A66 Northern Trans-Pennine Project

7.34 Applicant's Responses to the Examining Authority's Further Written Questions

Deadline 6

04 April 2023

INSET 1

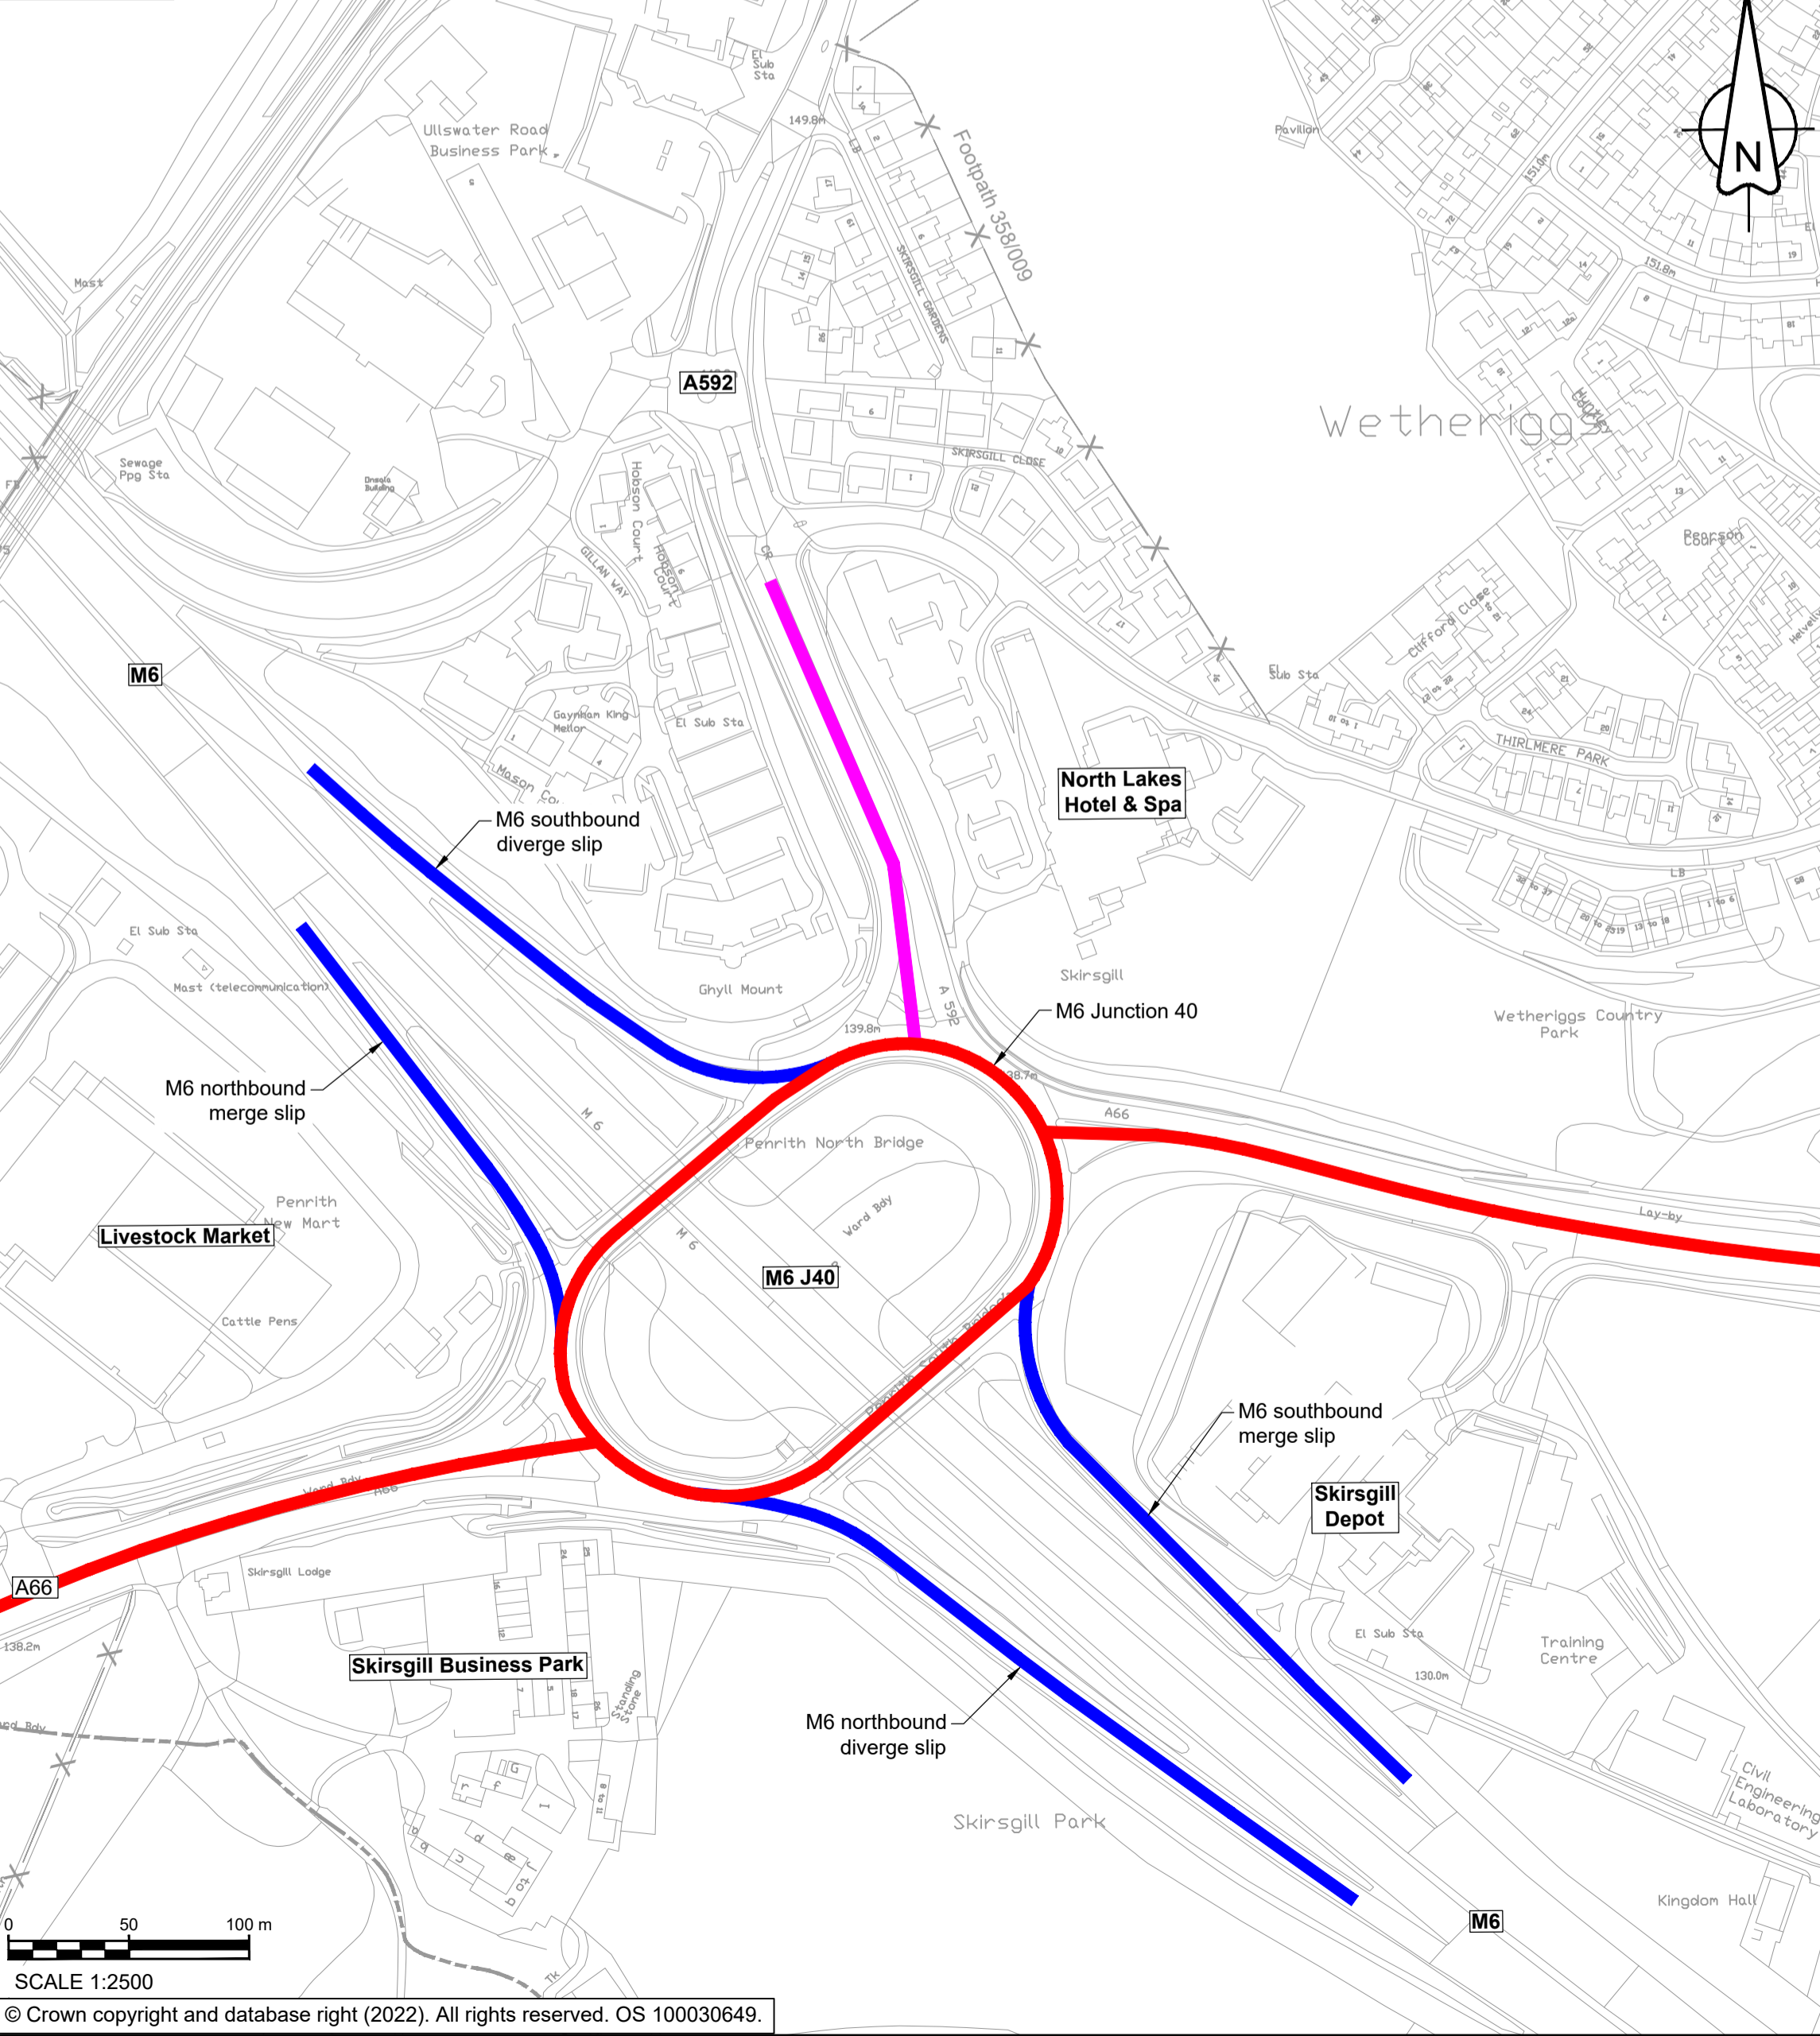
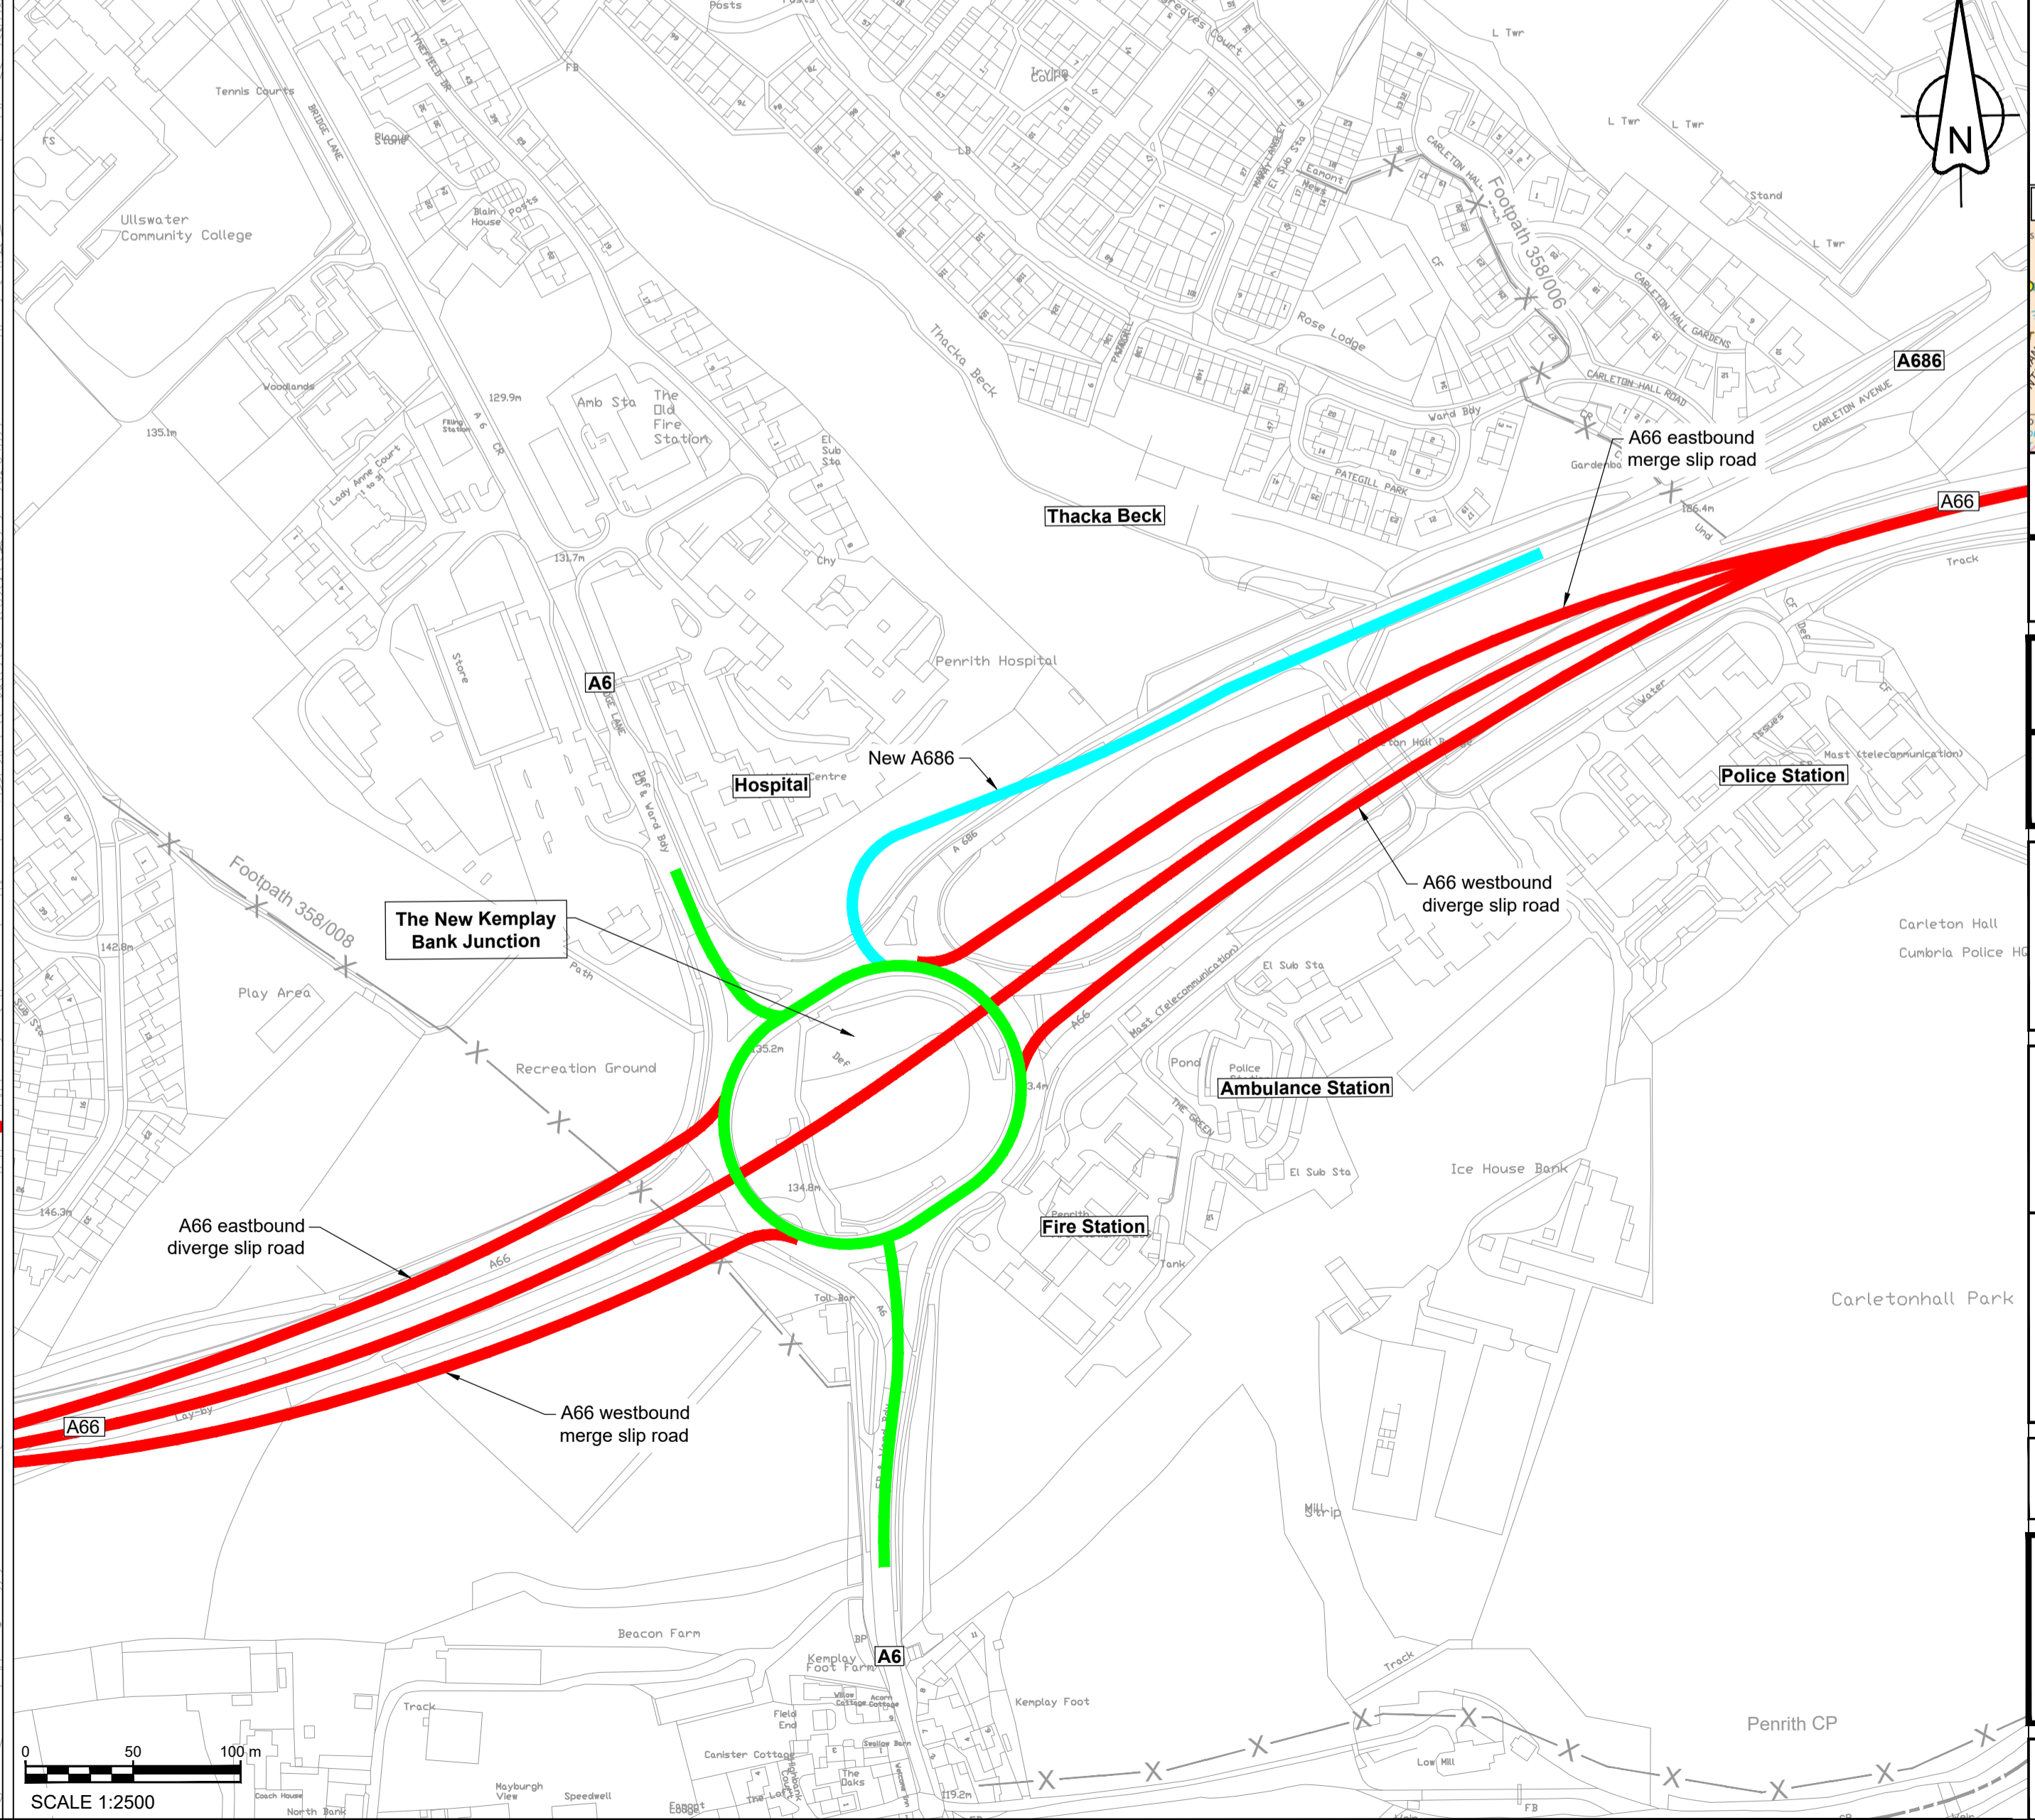
Ref Number	Subject	Response by	Question	Applicant's Response																																				
			that the classification number to the de-trunked section of the A66 should be unique and is under discussion with Cumbria CC. The latest draft DCO [REP5-012] still refers to the B1066, which is not a unique classification number. Explain why this has not been amended.																																					
GENERAL MATTERS																																								
GM 2.1	SoCGs	The Applicant All Relevant Interested Parties	Table 4.1 of the Statement of Commonality for SoCGs [REP5-003] sets out the position of each SoCG between the Applicant and the relevant Interested Party. The Applicant is requested to update the table setting when it expects the final and signed SoCGs will be submitted into the Examination. Interested Parties who disagree with their respective draft SoCGs are requested to inform the ExA at Deadline 6, Tuesday 04 April 2023.	<p>A revised version of Table 4.1 is provided below. This has been updated in the Statement of Commonality that will be submitted at Deadline 8.</p>
